Land at 30-32 Blyth Road, Hayes Parking Allocation Plan (LPA Ref. 68974/APP/2020/2345)

Introduction

Blyth Road, Hayes: **Car Parking Allocation plan** _Rev A

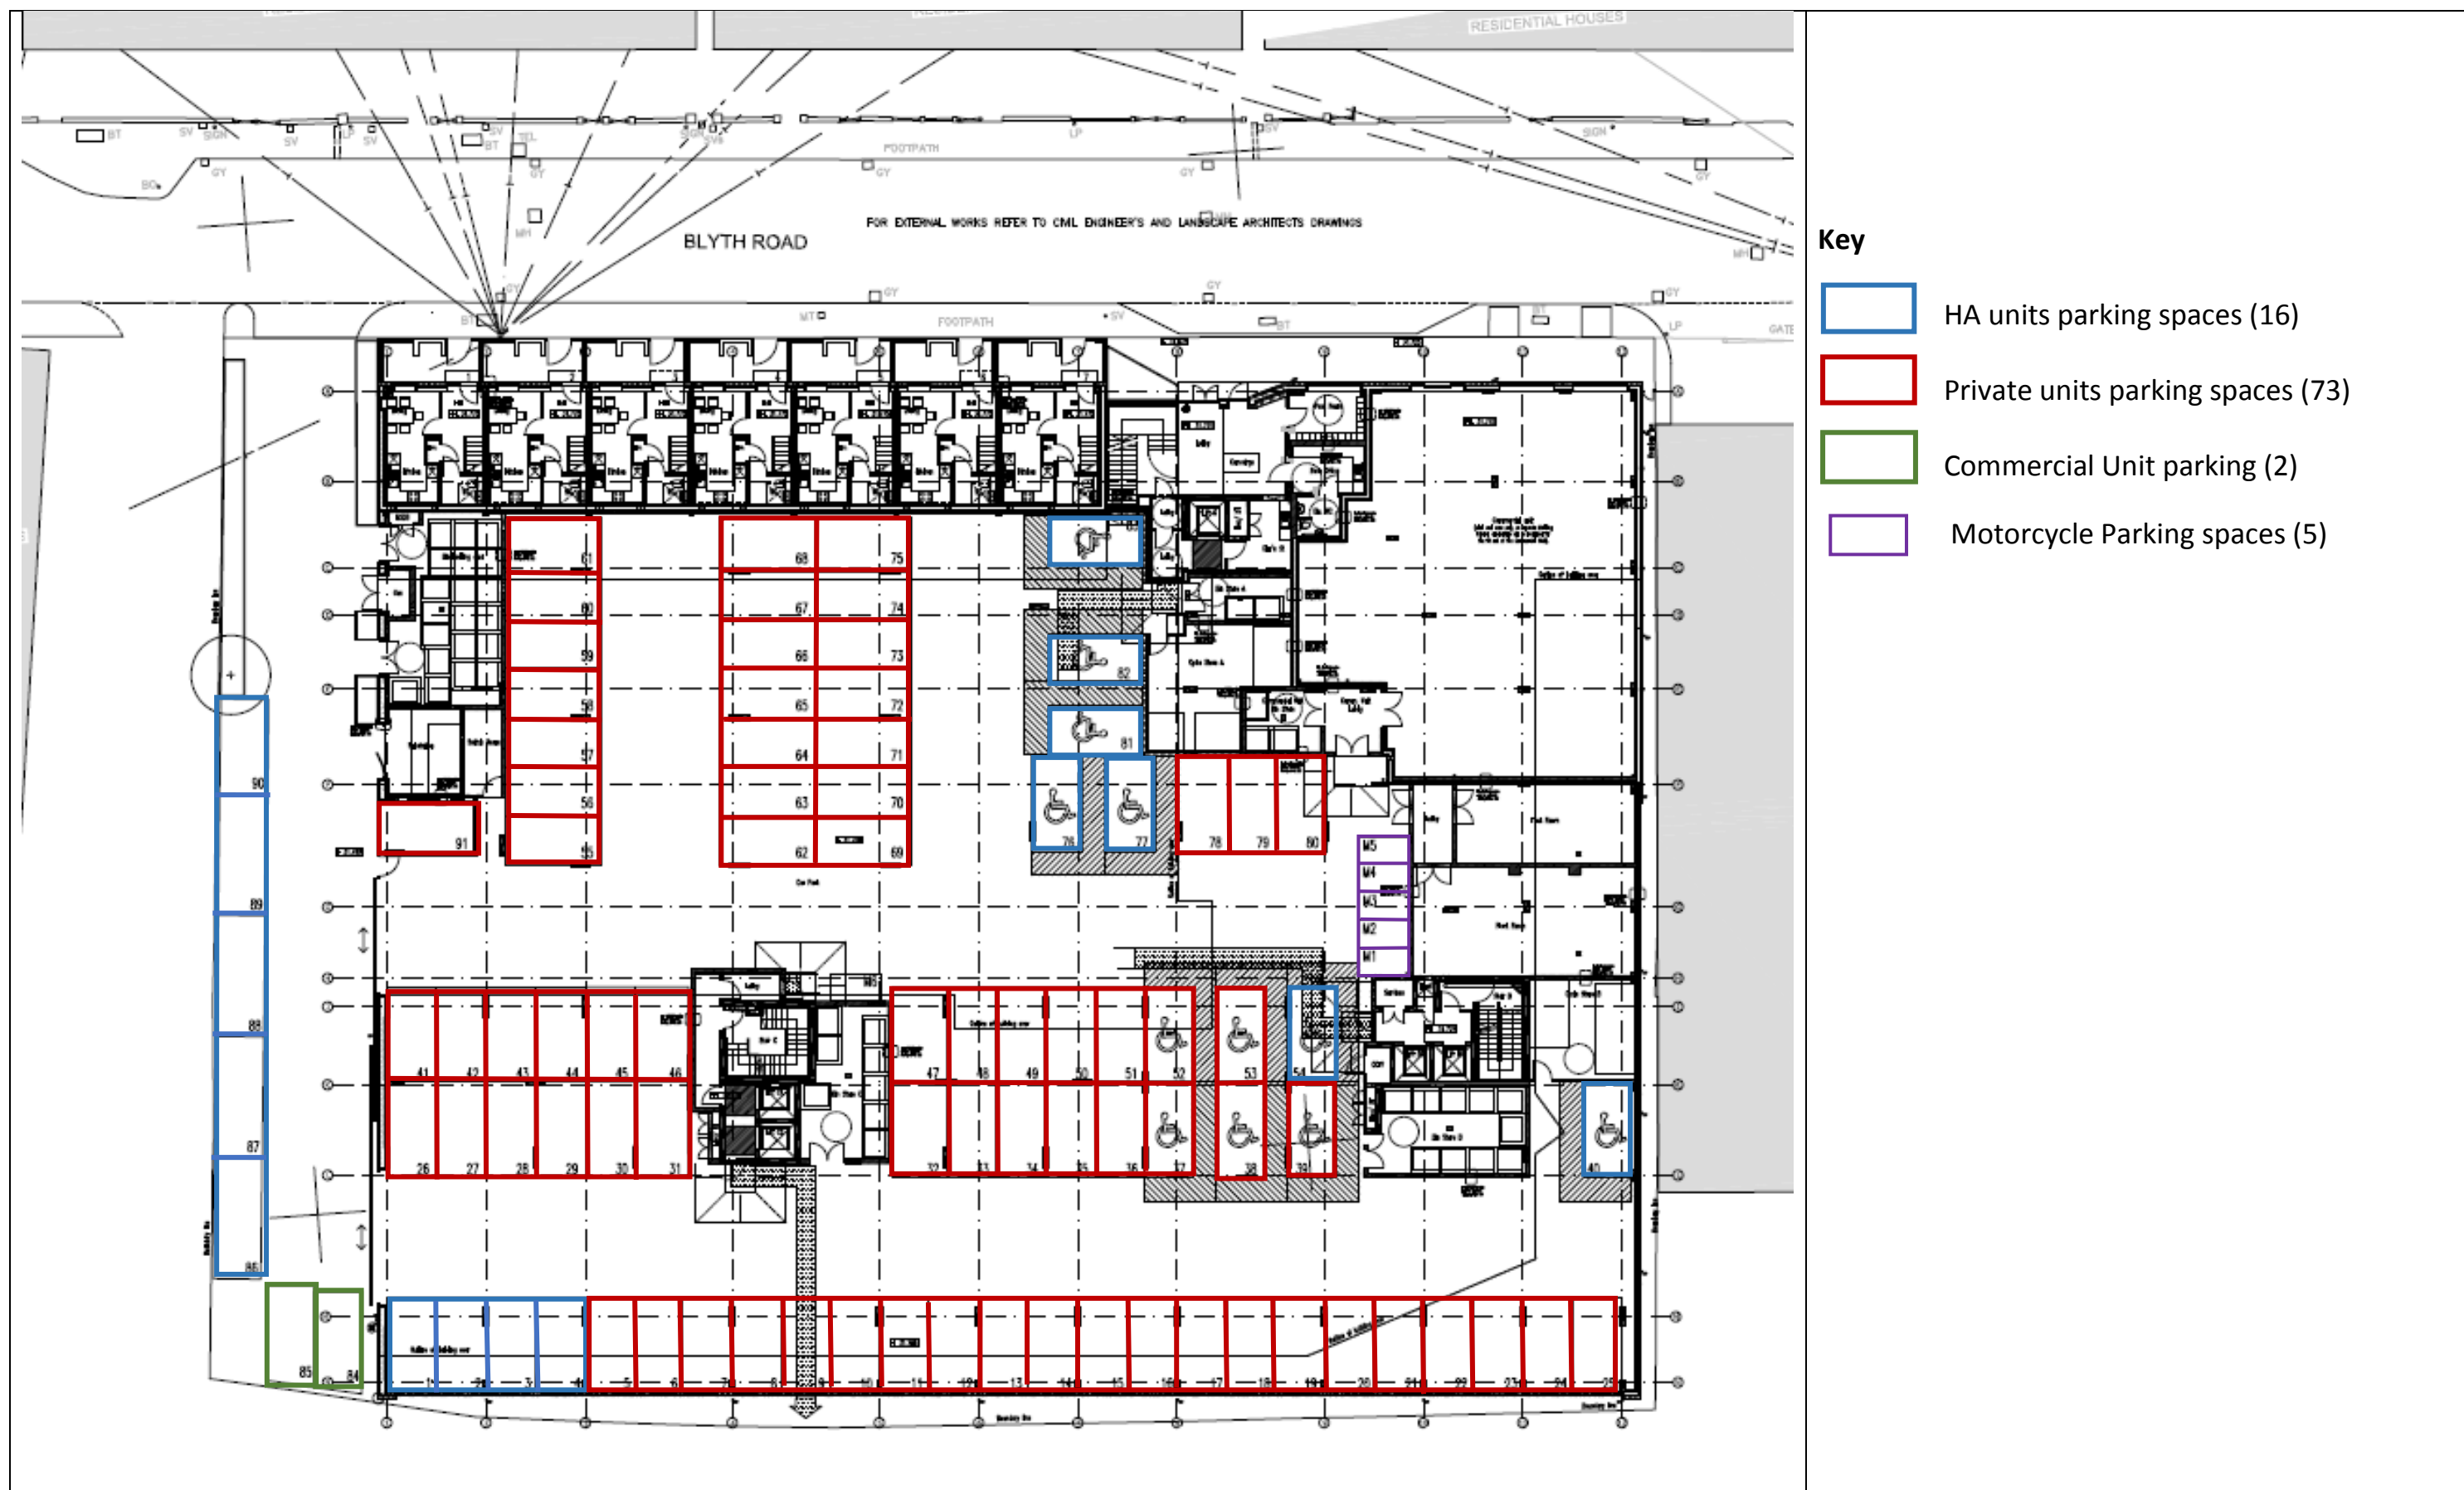
“The development has 88no. residential car parking spaces and 118no. units ranging in size from studio flats to 3 bedroom houses. The Highway Authority requires that all 12no. accessible units should be provided with a blue badge/wheelchair accessible parking space. Given that the 3 bedroom houses are more likely to be occupied by families who are also likely to lead car dependant lifestyles the Highway Authority require the remaining 76no. car parking spaces are allocated according to unit size with the larger units being allocated a parking space irrespective of tenure type. On this basis some of the 1 bedroom units and all of the studio units would not have access to on-site parking.

The Highway Authority require that Blyth Road, Parking Allocation Schedule – 2020_10_14 is revised accordingly. There are currently highway objections to this proposal as the occupants of some of the dwellings most likely to need parking do not have parking. This may lead to cars being parked injudiciously on-street increasing the risk to road safety, contributing to parking stress and hindering the free flow of traffic. There are highway objections to this proposal as it is contrary to the Hillingdon Local Plan: Part 2 Development Management Policies (2020) Policy DMT 1: Managing Transport Impacts – road safety, Policy DMT 2: Highway Impacts – traffic congestion and Policy DMT 6: Vehicle Parking – parking stress.”

In response to the first comment, the proposed scheme includes 12 blue badge/wheelchair parking spaces. This equates to 1 space per wheelchair accessible/adaptable unit (10% of the overall number of units within the scheme) and the allocation is detailed in the amended parking allocation schedule. This provision is split to provide 7 blue badge spaces for the shared ownership units and 5 blue badge spaces for the private units.

Taking the above into account, the proposed parking allocation has been amended in response to the comments raised:

- 2 commercial parking spaces;
- 73 parking spaces for the private units (allocated at 1 space per unit with not all 1 bedroom units being provided with spaces. The 3 x 3 bedroom private flats will each have a car parking space);
- 16 parking spaces for the affordable units. These are broken down as follows:
 - o 5 x standard parking spaces (No. 86-90) for the 3 bedroom affordable rented 3 bedroom houses;
 - o 4 x standard parking spaces for the 3 bed shared ownership houses within the main car park area;

- 2 x blue badge/wheelchair parking spaces for the 3 bedroom shared ownership wheelchair accessible/adaptable units within the main car park area; and
- 5 x blue badge/wheelchair parking spaces for the 2 bedroom shared ownership wheelchair accessible / adaptable units within the main car park area.

The proposed parking allocation for the affordable accommodation has been increased by 7 spaces in response to the comments raised. The Parking Schedule and Allocation Plan have been updated to reflect the proposed amendments detailed above.
